MECKLENBURG COUNTY  
Park and Recreation Department

MEMORANDUM

**RE:** Rezoning Petition #2023-028  
PID# 02959103

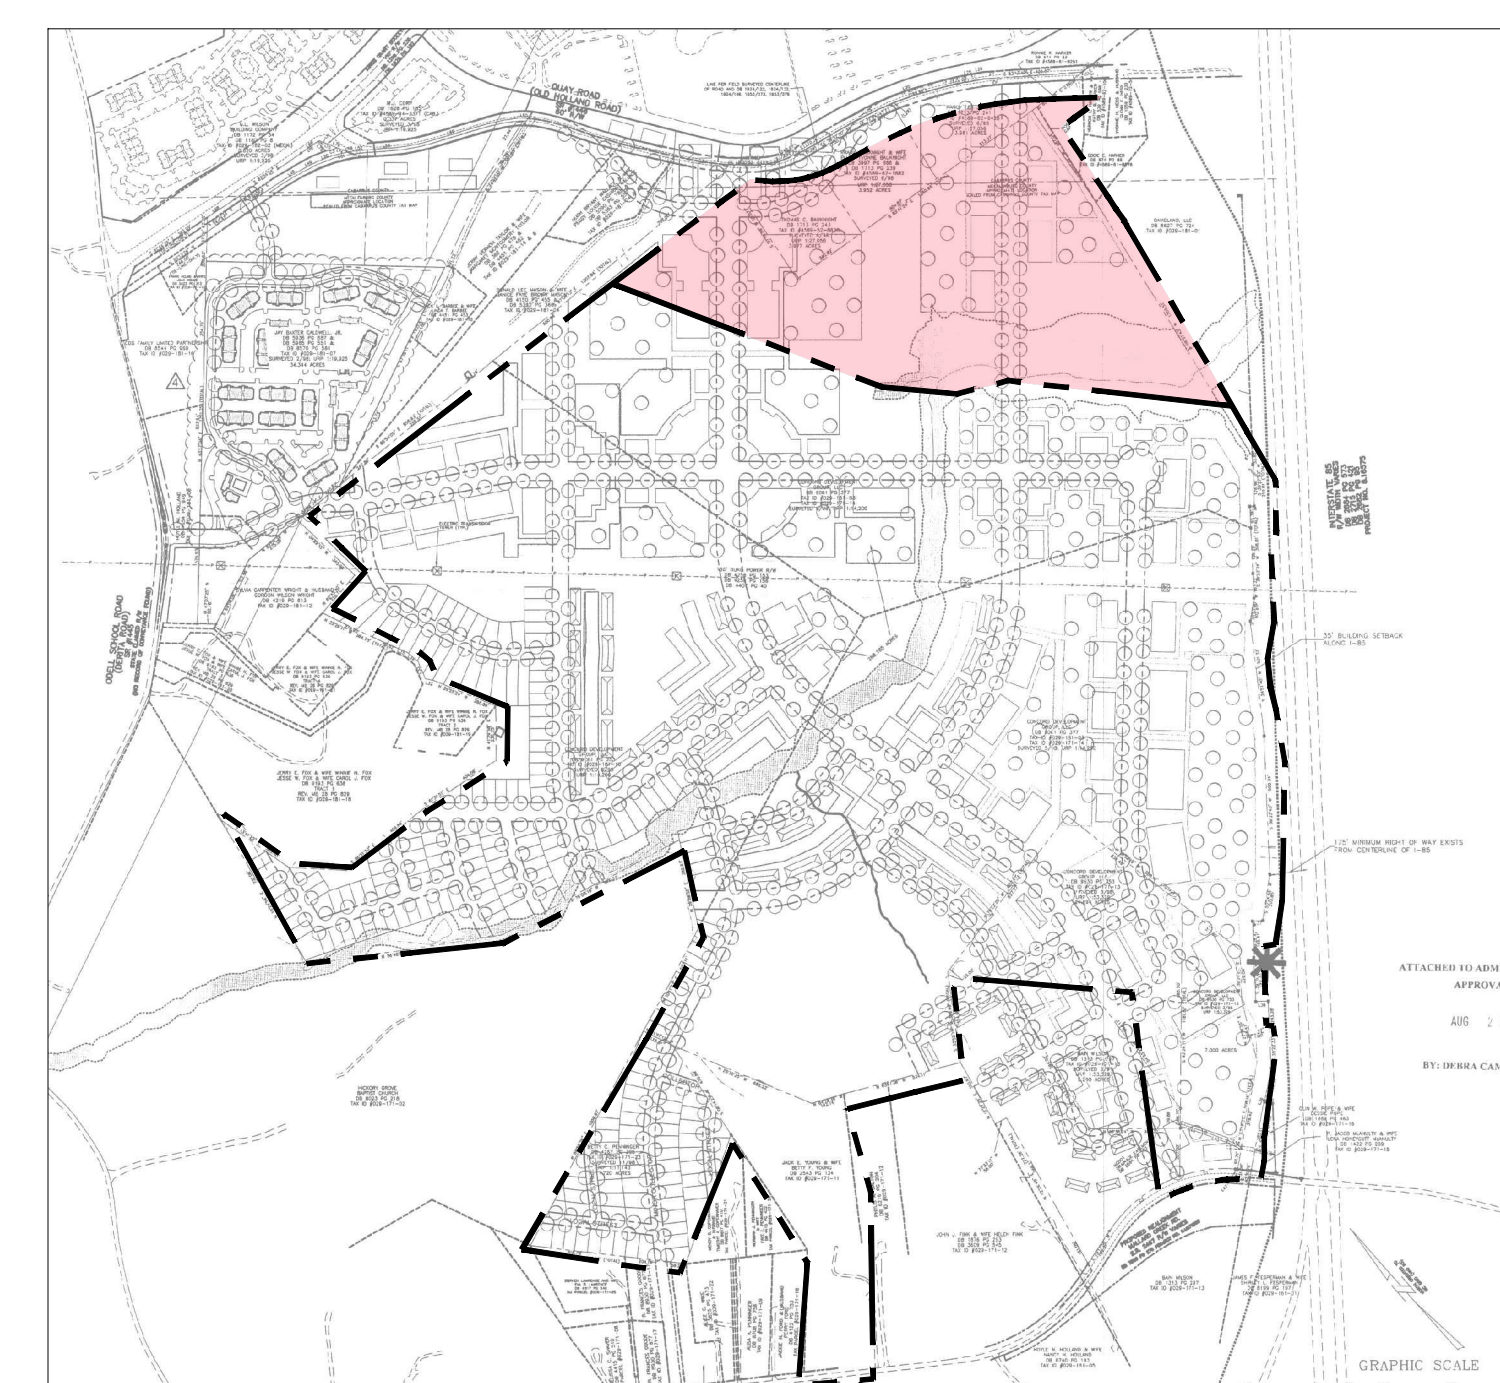
Plans current reference previous Park and Recreation commitments from Rezoning 2021-028. MCPR requests that the petitioner accommodates a minimum of 1.8 acres of the 12-acre park dedication commitment on this site. Note that the requested park land shall be adjacent to a public right-of-way for access and should provide connectivity to the larger 12-acre park land area on the adjacent development.
